From: Colin Alden <Colin.Alden@dartford.gov.uk>
Sent: 18 November 2019 15:23
To: Hannah Donnellan; Planning Comments
Subject: 19/05000/HYB | Hybrid application comprising, in outline: development of business space (use classes B1a/b/c) of up to 27,659 sq m GEA; works within the X enclave relating to energetic testing operations | DSTL Fort Halstead Crow Drive Halstead Seve

I have reviewed the submission relating to noise and have some queries concerning the information provided and the guidance used in the assessment. Whilst it appears the assessment takes account of the latest National Planning Policy Framework then likewise they should be using the latest Planning Practice Guidance, the guidance on noise relates to paragraphs 170(e), 180(a)&(b) and 182. The assessment does not appear to have addressed the requirements of paragraph 182 of NPPF for the retained employment on the site and whilst BS 4142:2014 has been revised it makes no difference for this assessment, the World Health Organisation Environmental Noise Guidelines for the European Region should be considered in relation to road traffic noise.

Figure 02.1

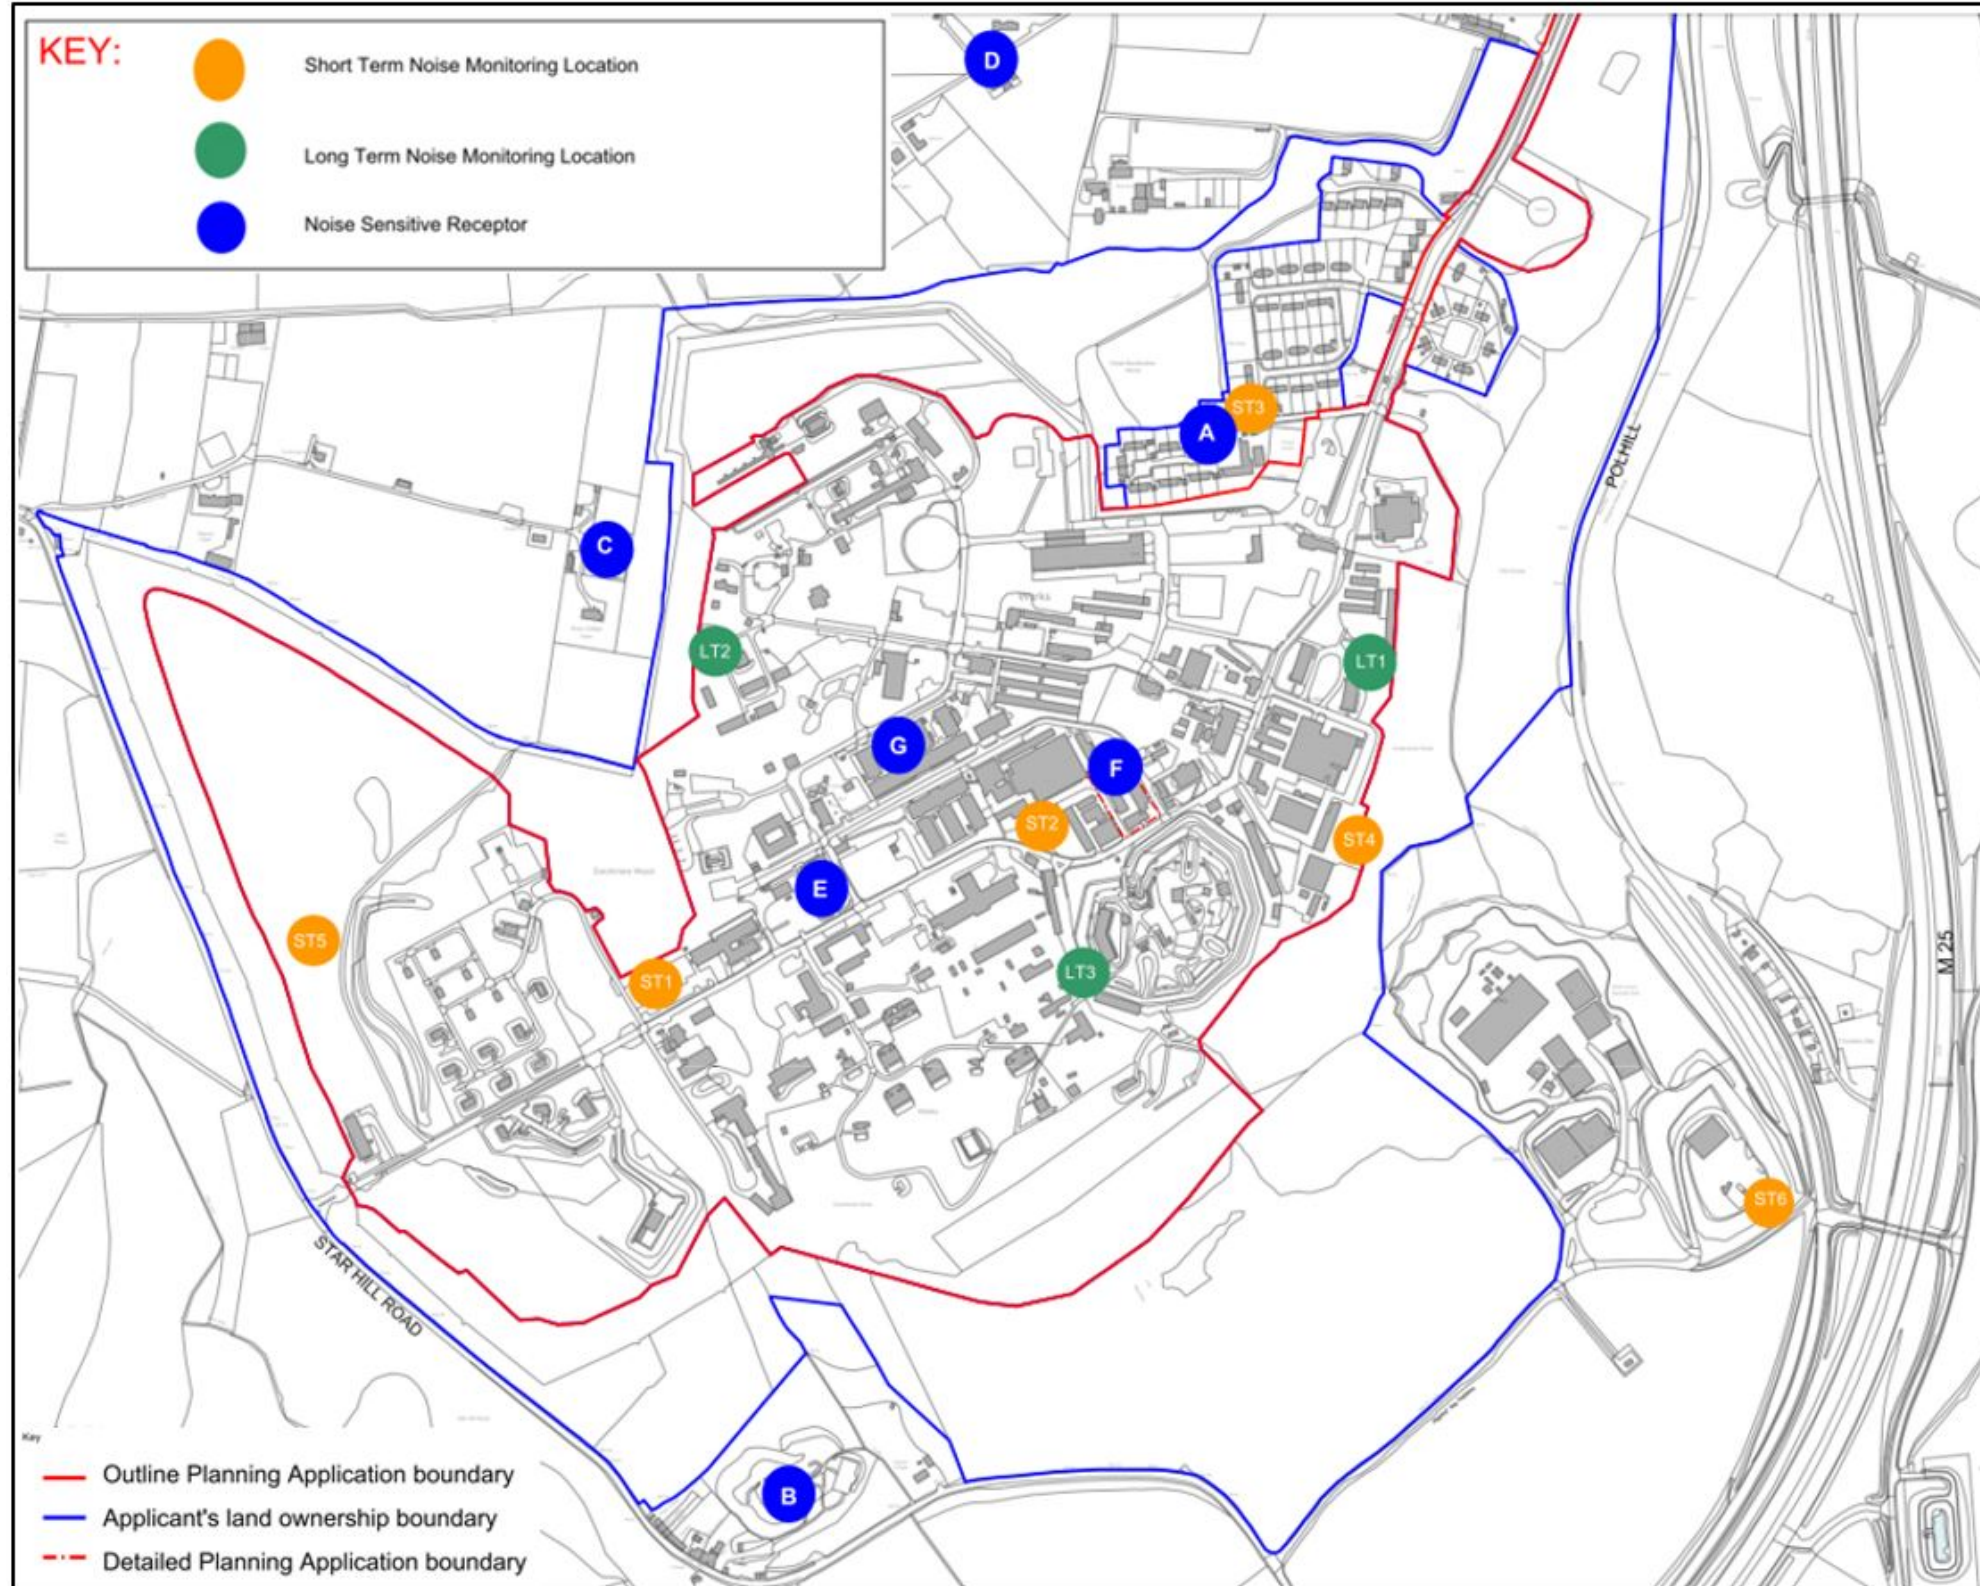
Furthermore, in light of the retained employment area, this has protected rights in terms of noise under paragraph 182 of the NPPF, however we appear to have no specific information on noise from “energetic testing”, this appears to be a significant oversight when building an accurate picture of the potential future noise environment of the development site.
